# CLAREMONT RANCH FILING NO. 9B

**AN AMENDED** PLAT OF LOTS 1-4, CLAREMONT RANCH FILING NO. 9A  
IN THE NORTHWEST QUARTER OF SECTION 4, T.14S, R.66W OF THE 6TH P.M.  
COUNTY OF EL PASO, STATE OF COLORADO

# Markup Summary

CLAREMONT RANCH FILING NO. 9B

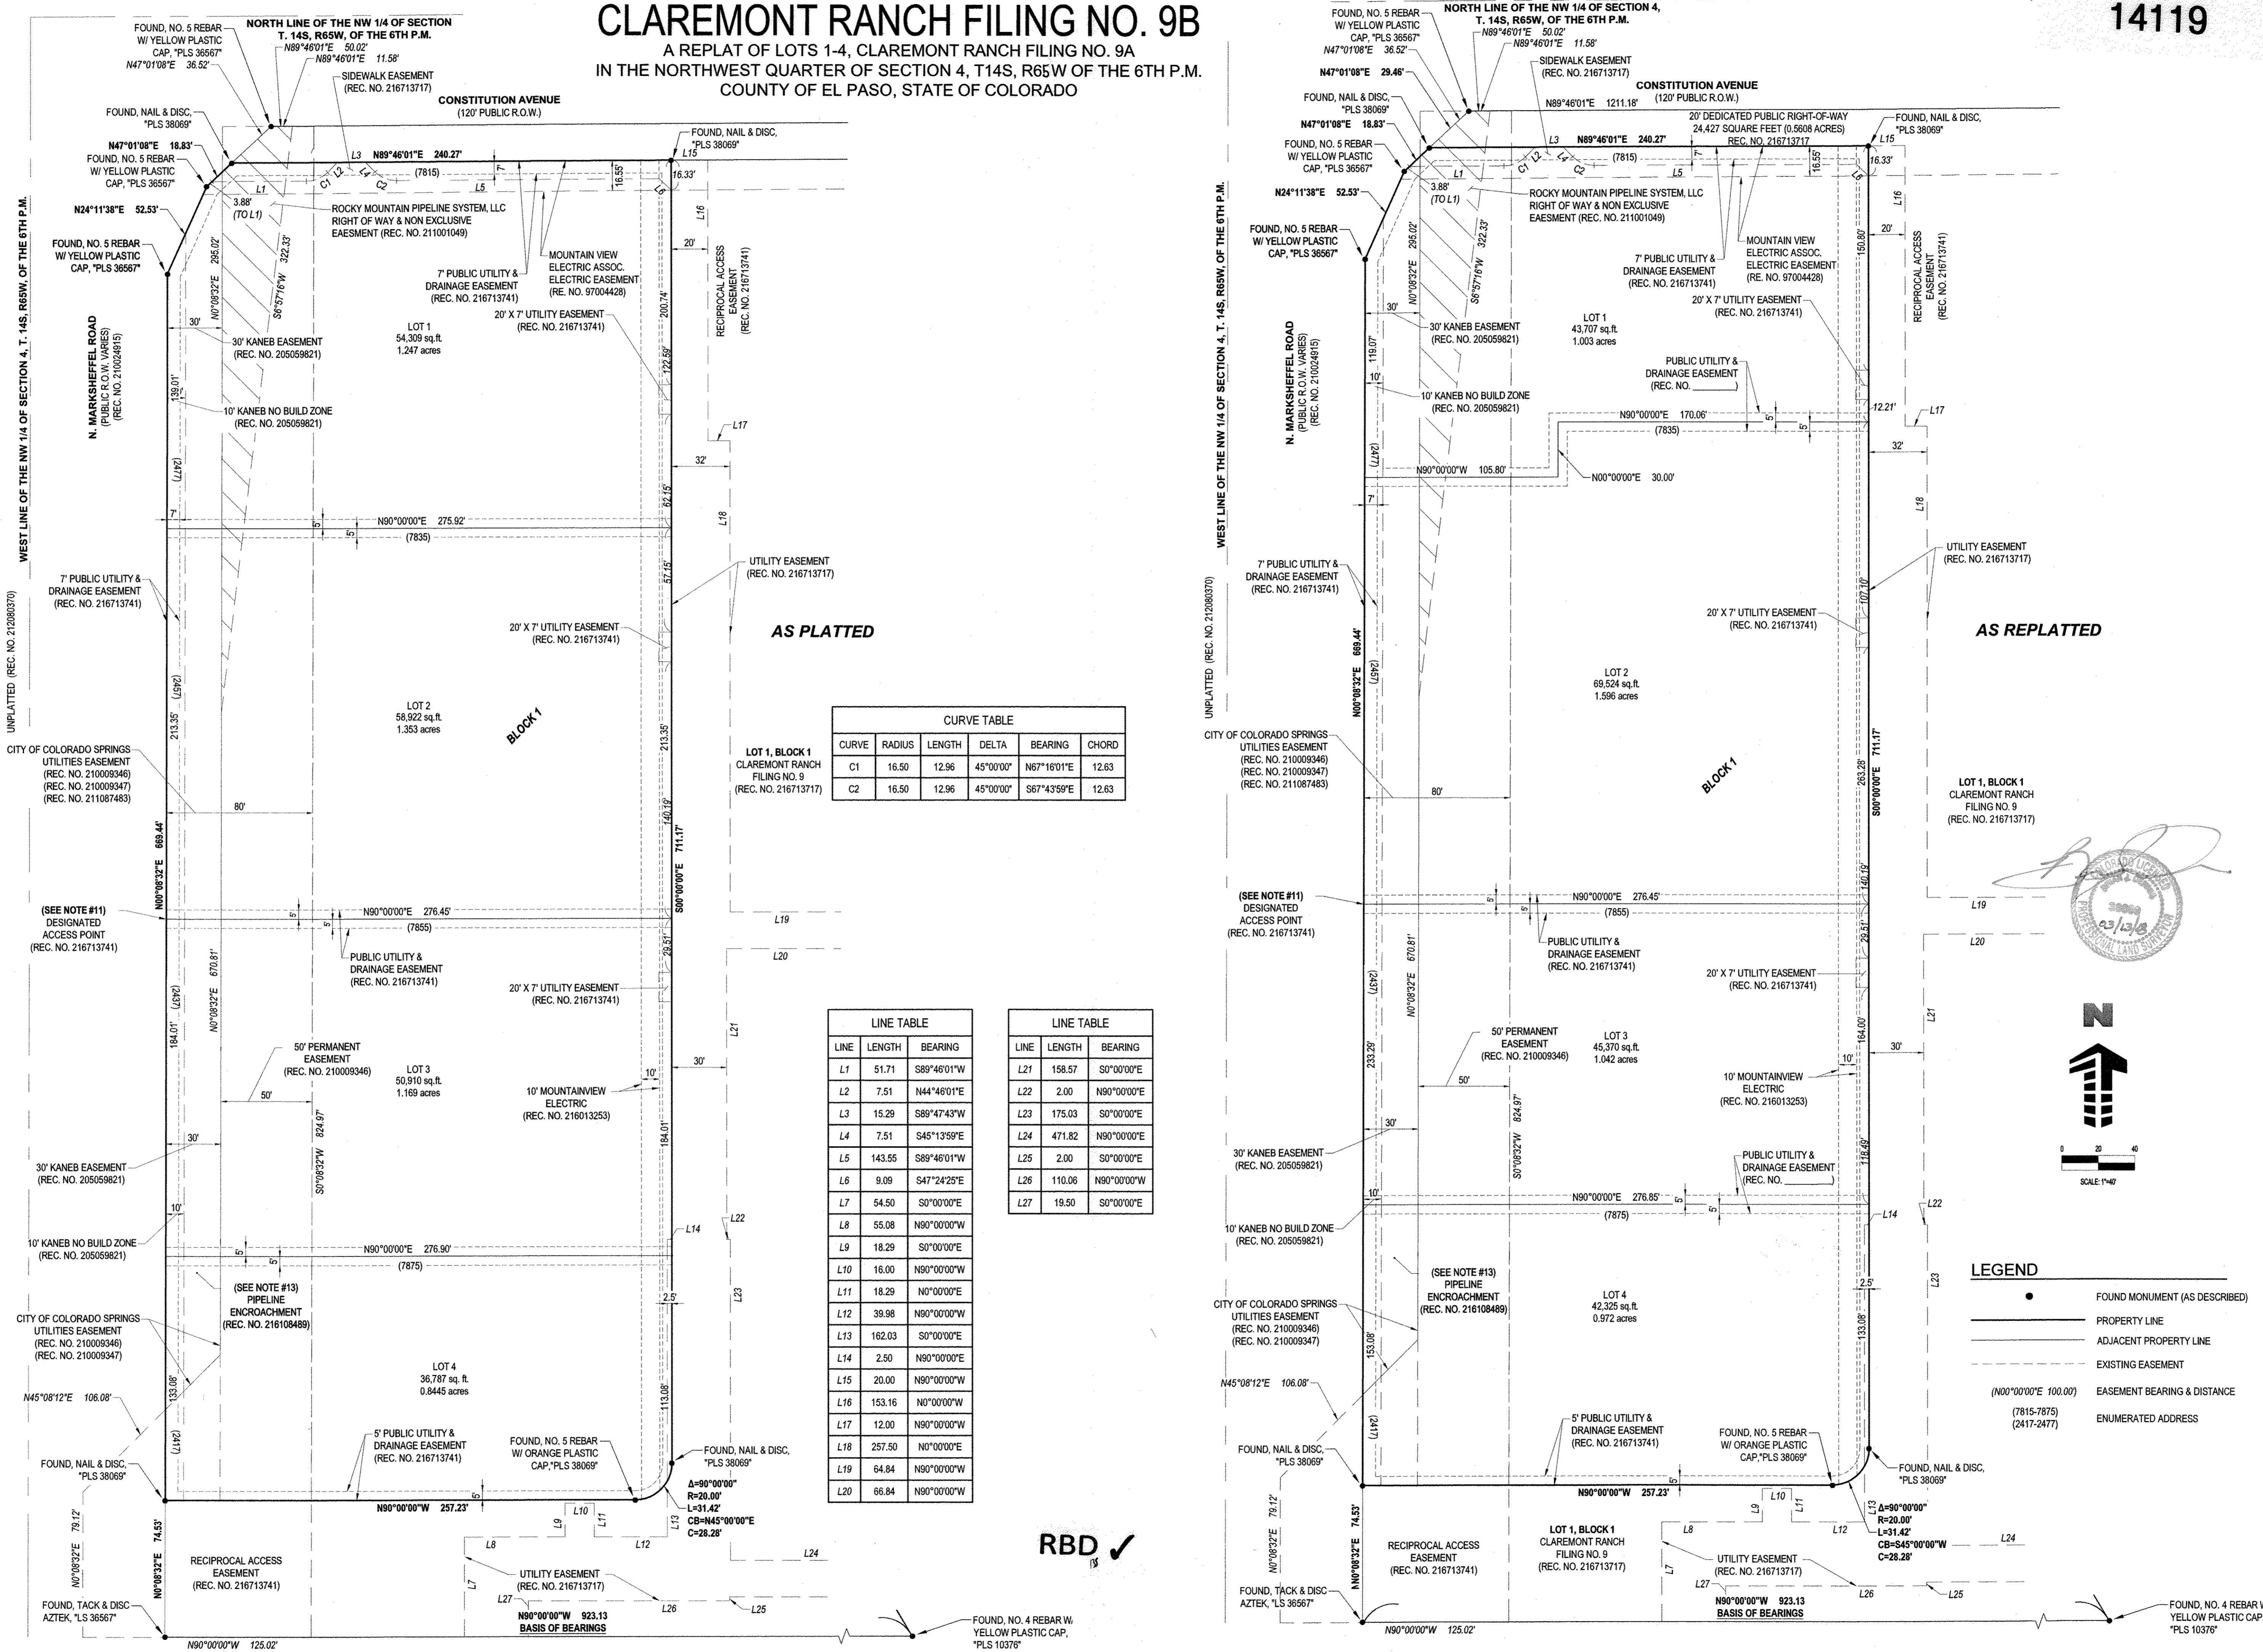
Additional drainage easements within Lot 2 may be needed to allow Lot 1 to connect into the existing stormdrain stub. Verify asbuilt for stub location

Add north arrow, scale and bar scale

Additional drainage easements within Lot 4 may be needed to allow Lot 3 to connect into the existing stormdrain stub. Verify asbuilt for stub location

COLORADO SPRINGS  
EASEMENT  
(REC. NO. 210009348)  
(REC. NO. 210009347)  
(REC. NO. 210087483)  
210009348

Vacate/Replat

Refer to Utilities comments, Book 116, Page 32 needs to be changed and/or reception number changed to 216713741
